## **Submission Objecting to State Significant Development (SSD-79261463)**

**1-3 Reid Street & 2-4 Woodside Avenue, Lindfield NSW 2070**

GROUND FLOOR PLAN

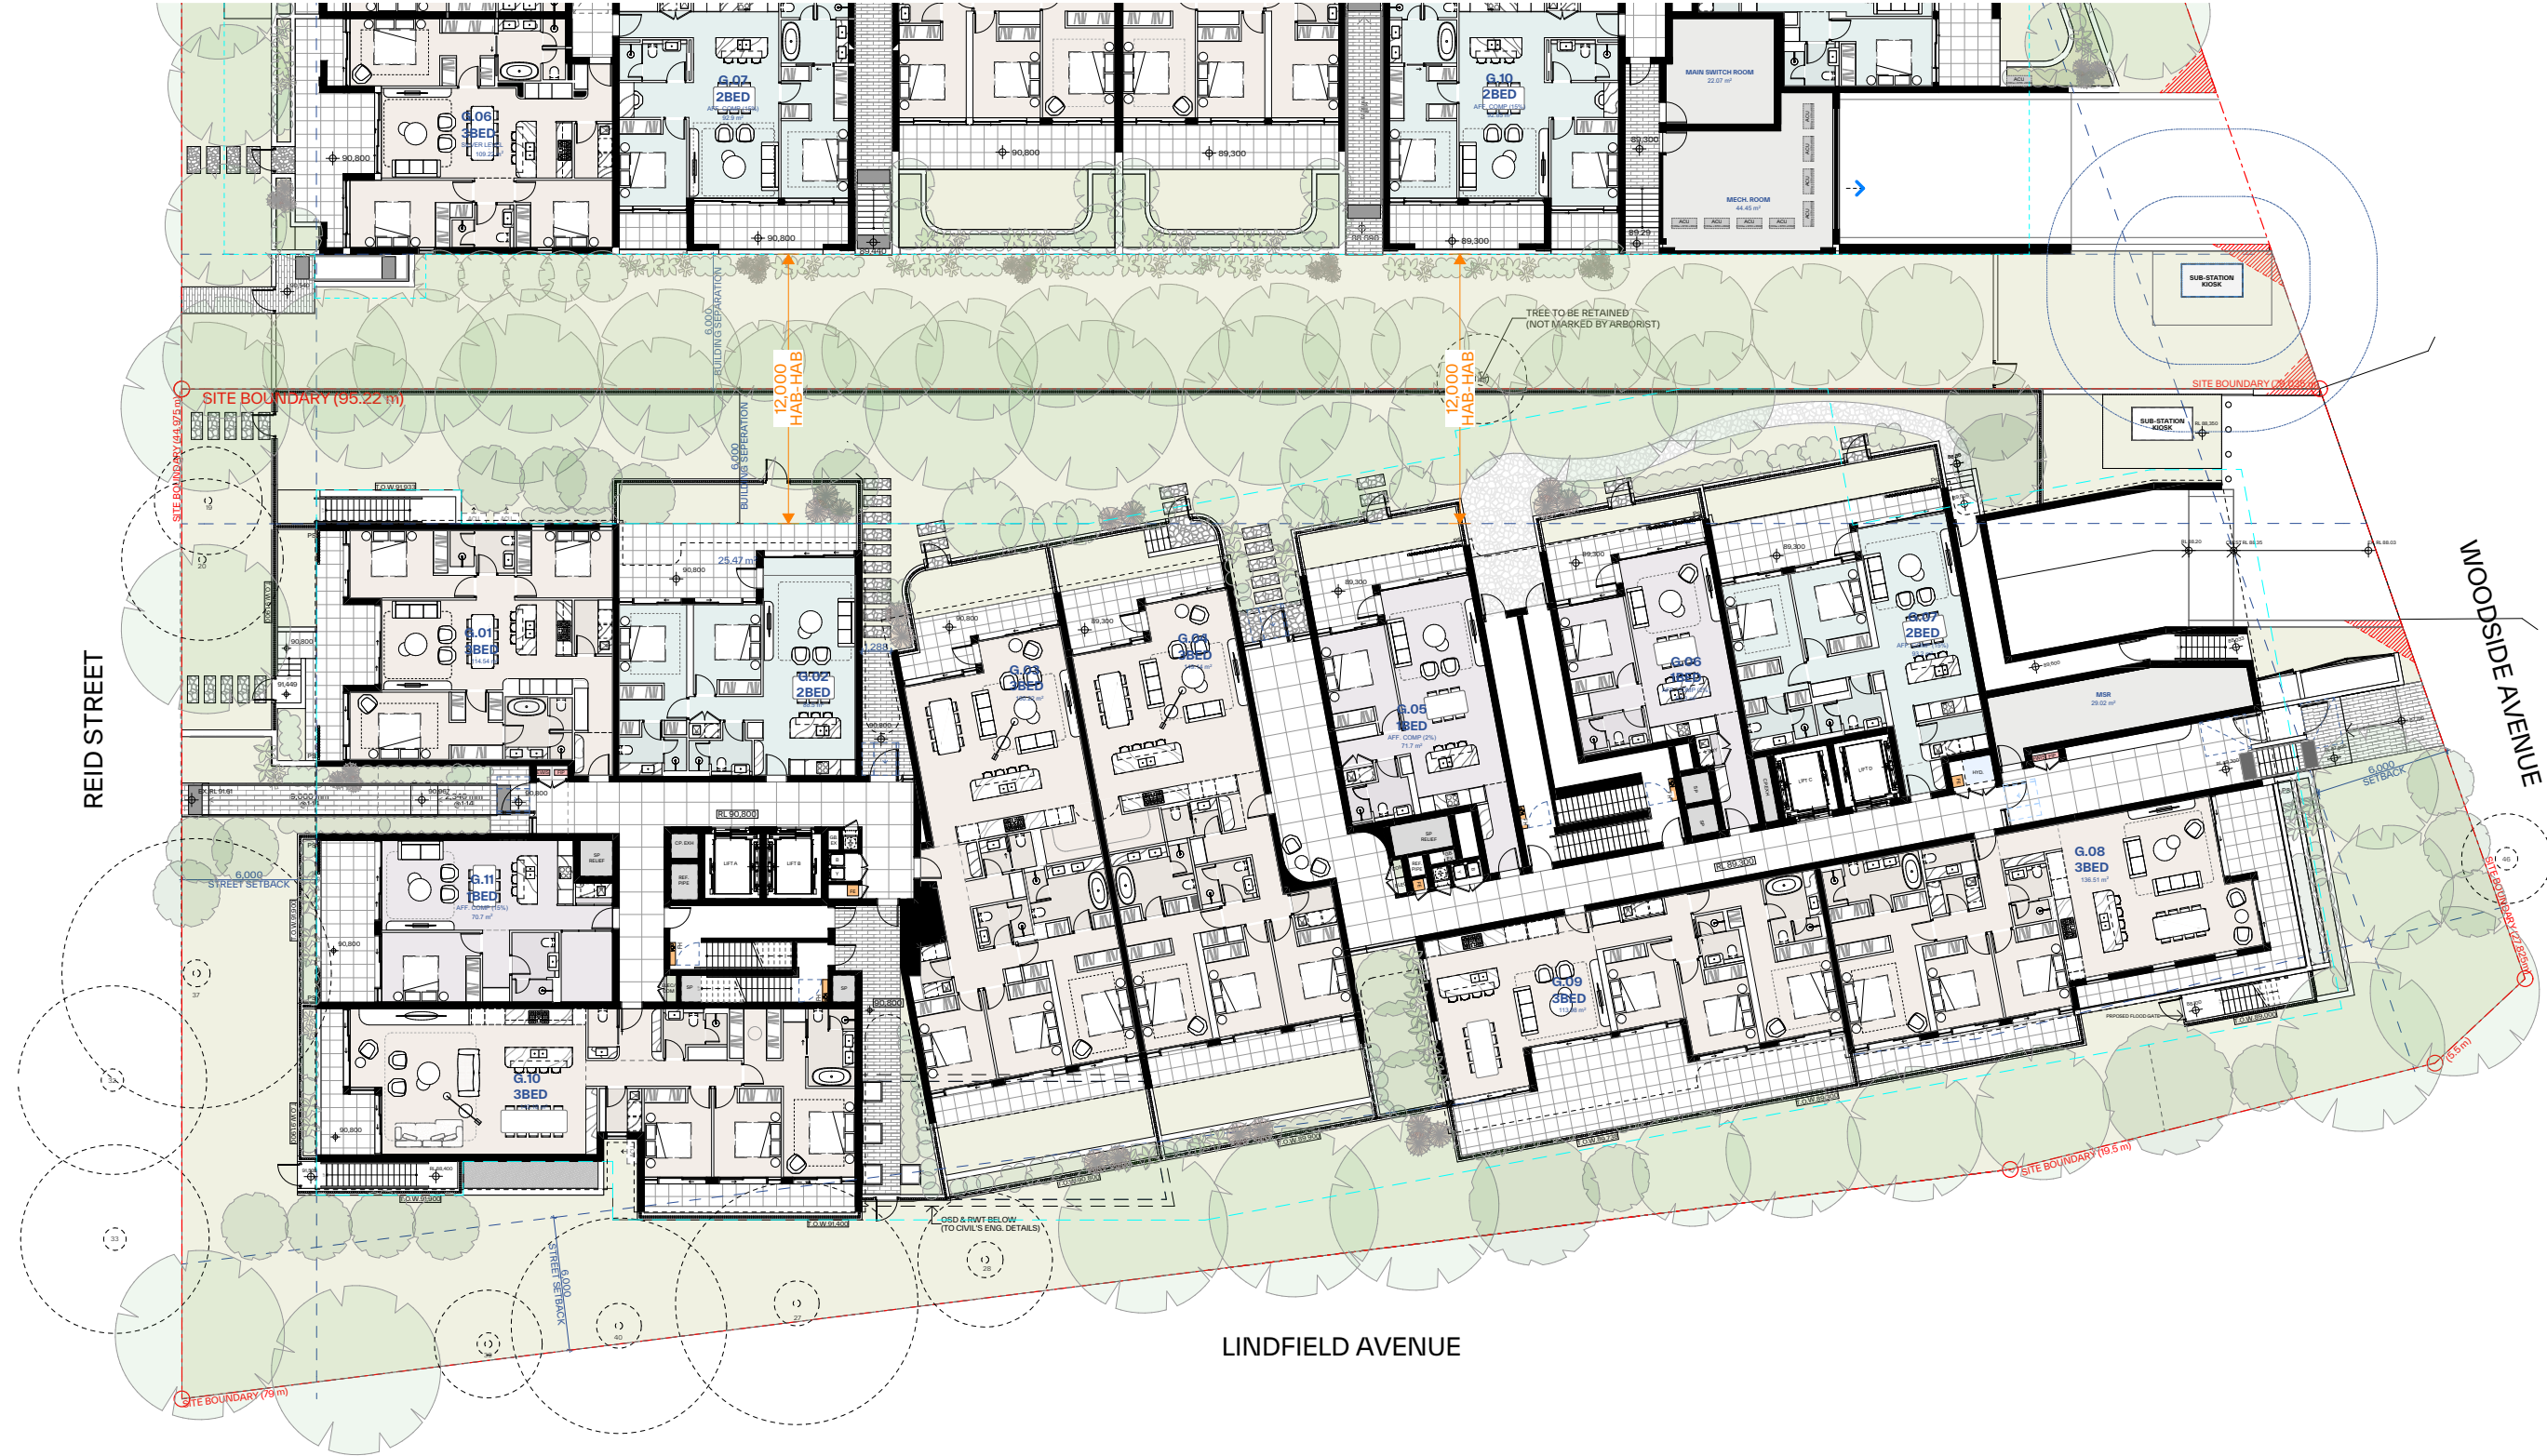
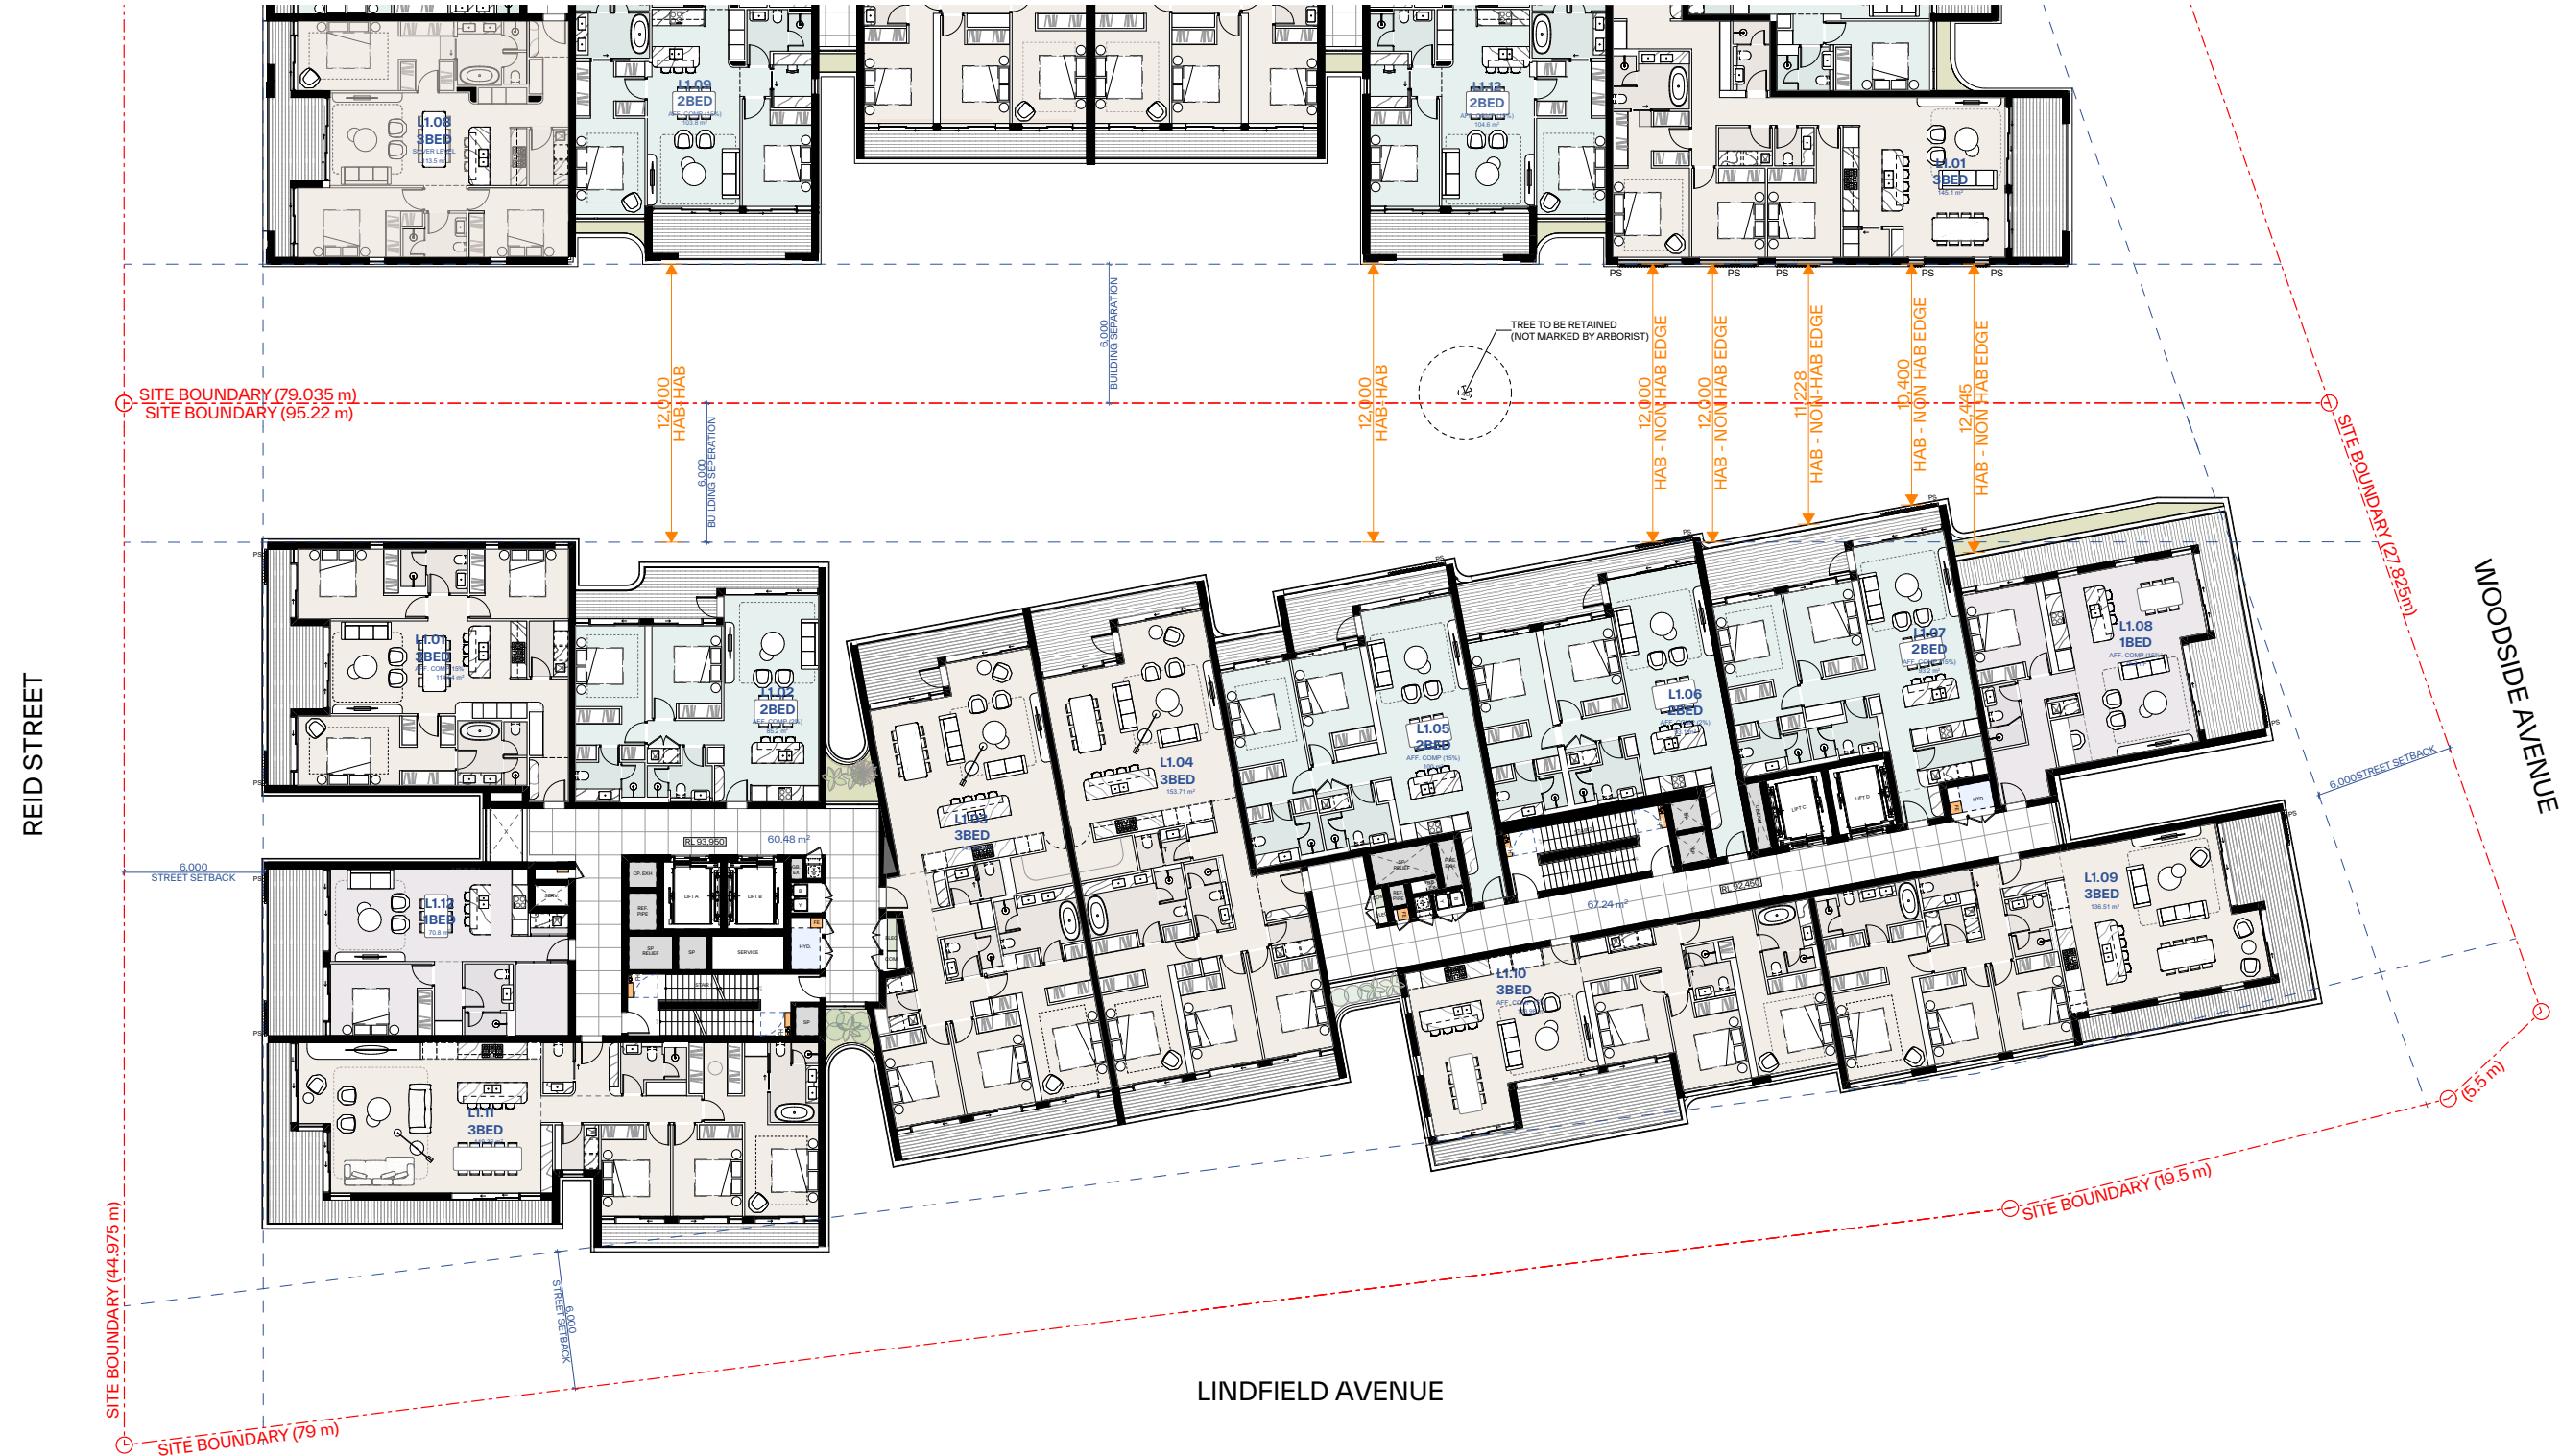
- **Non-Compliant Setbacks:**
  - Ground-level to Level 3 setbacks (6m) are insufficient to mitigate the building's imposing bulk and scale. These setbacks are not even uniformly 6m with encroachments (e.g. balconies and egress stairs) undermining compliance (Figure 39 & 40 of EIS).
